CITY OF ALBUQUERQUE

April 25, 2013

Re: American Tire Warehouse Addition, Grading and Drainage Plan
Engineer's Stamp Date 03-27-2013 (C-17/D015)

A1 SITE GRADING PLAN
1"=50'-0"

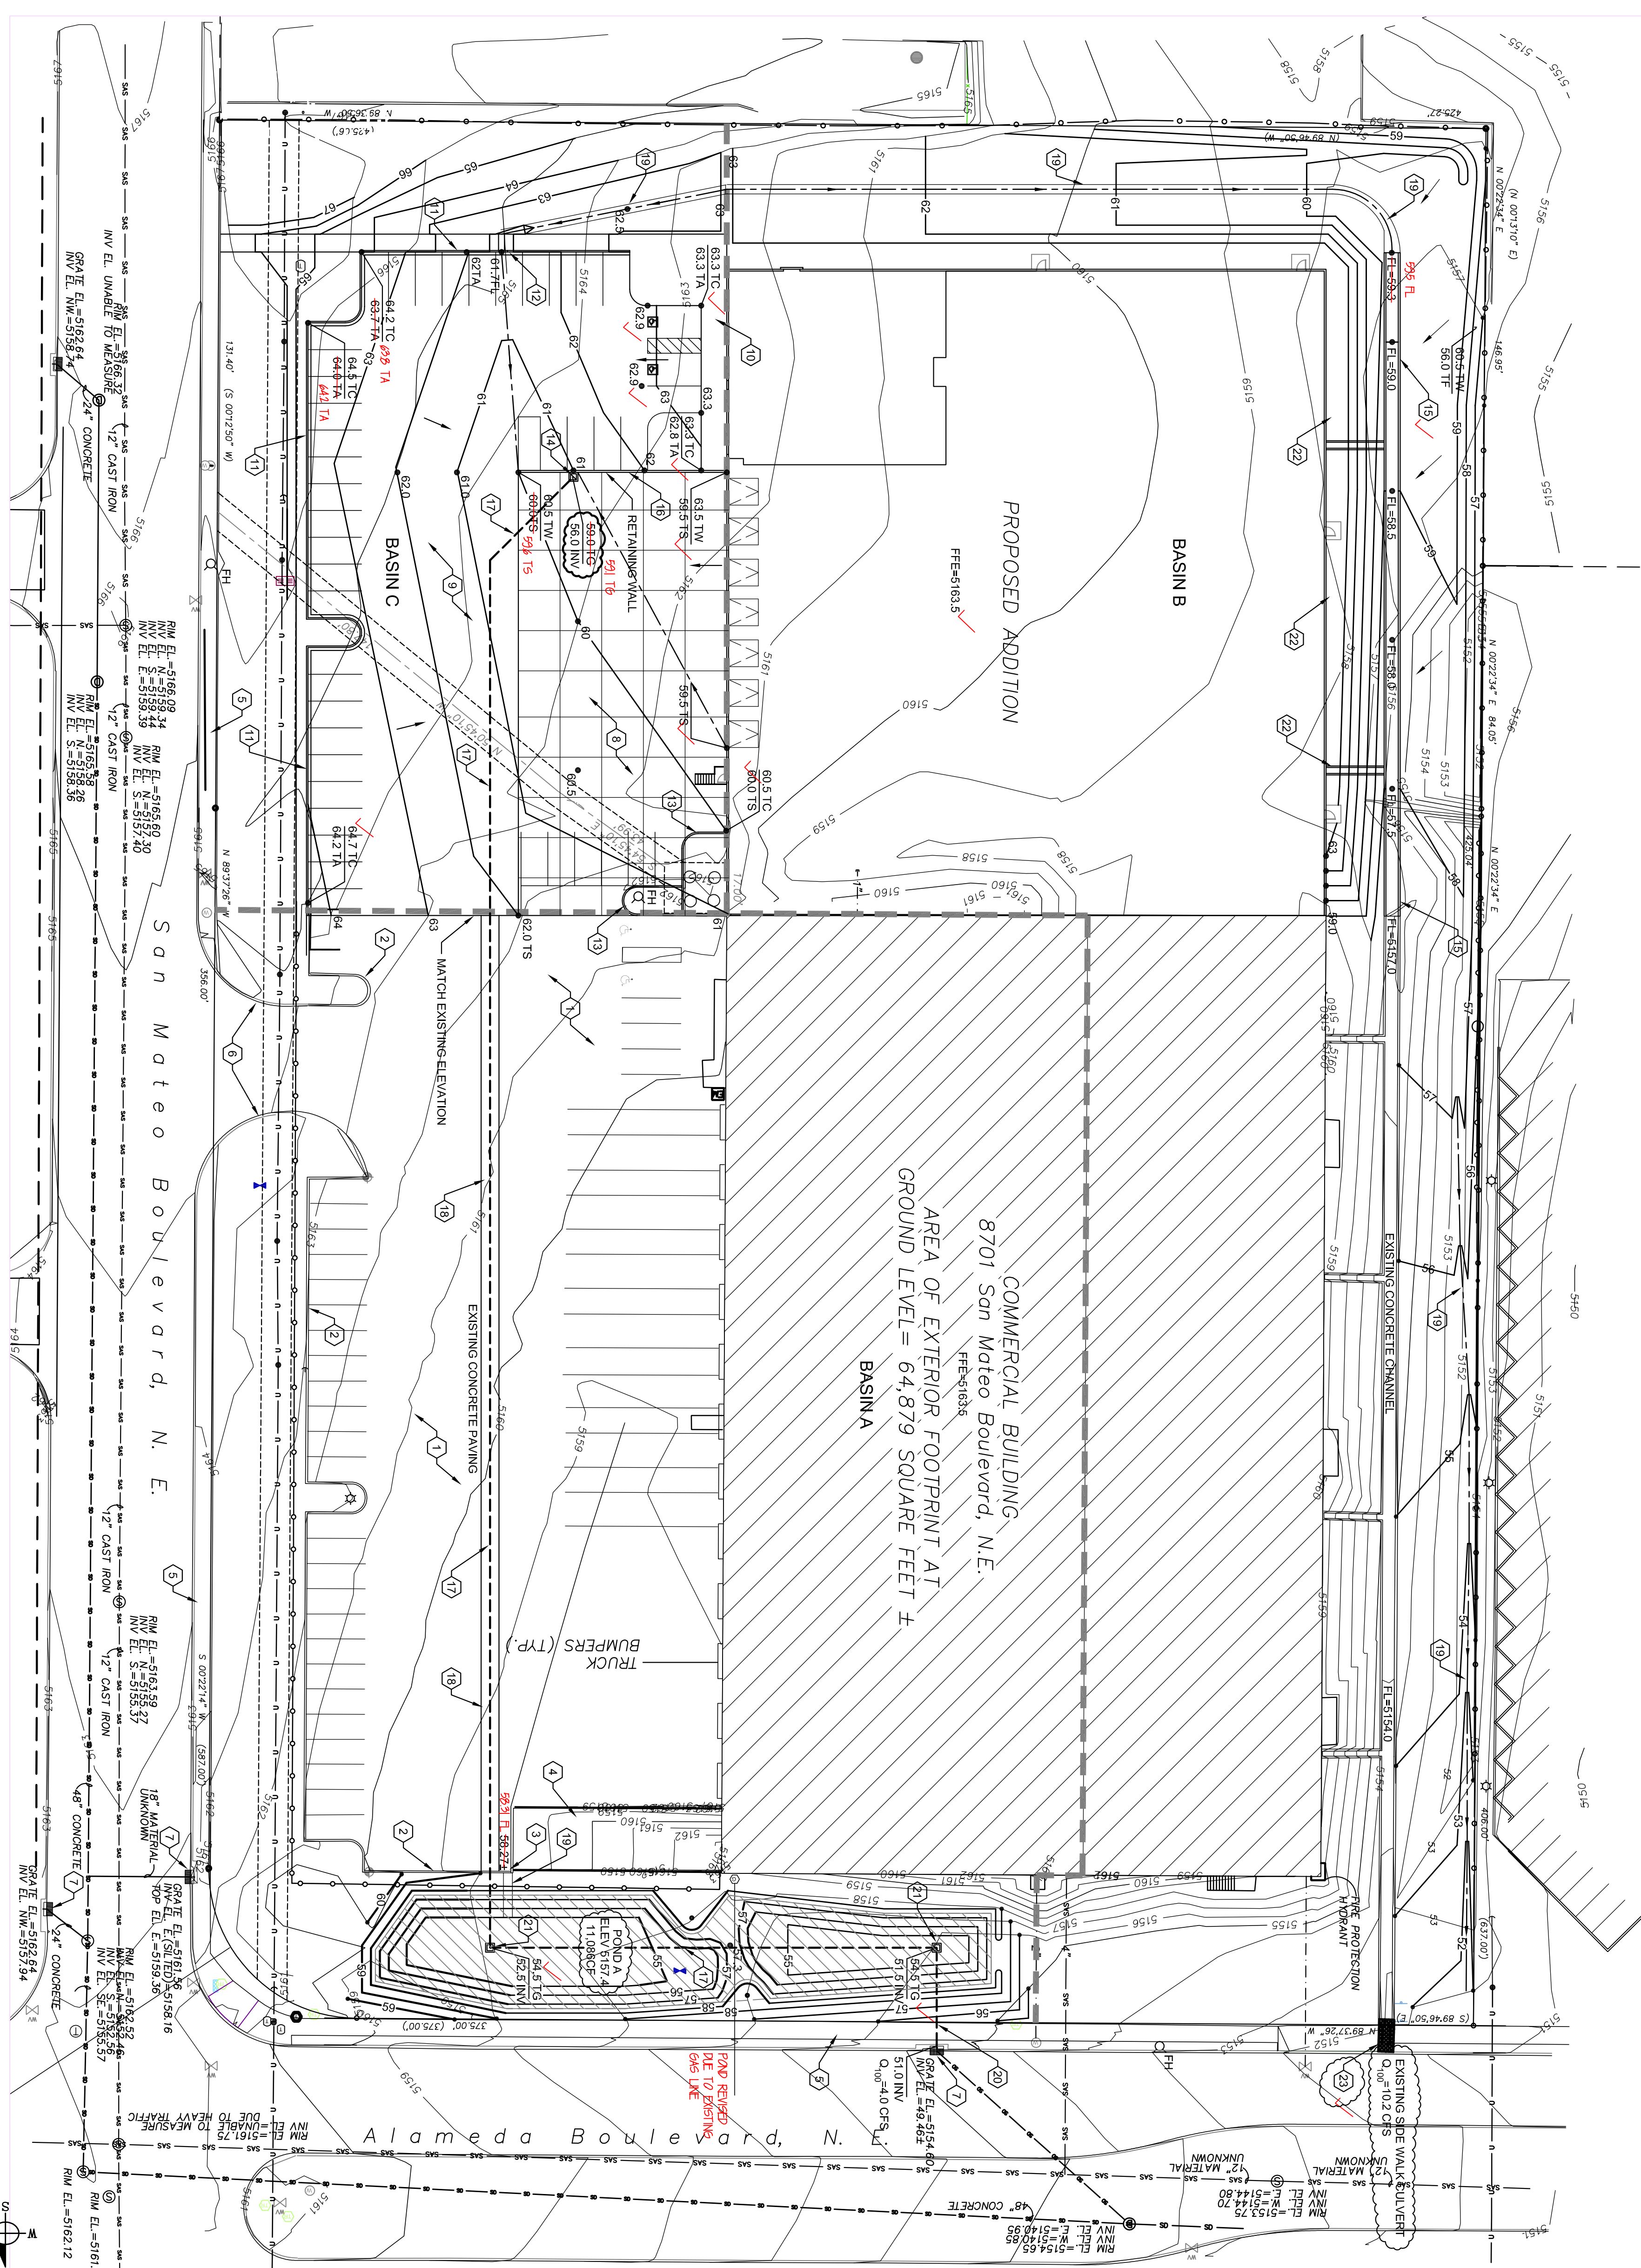
- Please provide routing calculations to show how the proposed pond will drain over time.
- It appears that the proposed discharge rate of 14.4 cfs will exceed the limit set forth by the SAD 201 drainage report of 14.2 cfs; please provide all supporting documentation reflecting this limitation.

- The pipe connection to the back of the existing inlet will need to be constructed under SO-19 guidelines and inspected. The SO-19 standard language should be placed on the grading plan.

- It appears that a portion of the flows on the southwestern edge of the property are being directed towards the adjacent lot. How will these flows be contained?

- Both Basin A and a portion of Basin C should not be calculated as containing "100% Treatment Type A" as existing conditions. Basin B also has been mass graded and should not be considered treatment type A in its existing condition.

- The 100-year water surface elevation should be shown on the proposed pond along with the pond volume; please provide a legend on the plan for clarification of line types. If the pond will take longer than 6 hours to drain a 24-hour storm event will be required for pond sizing.
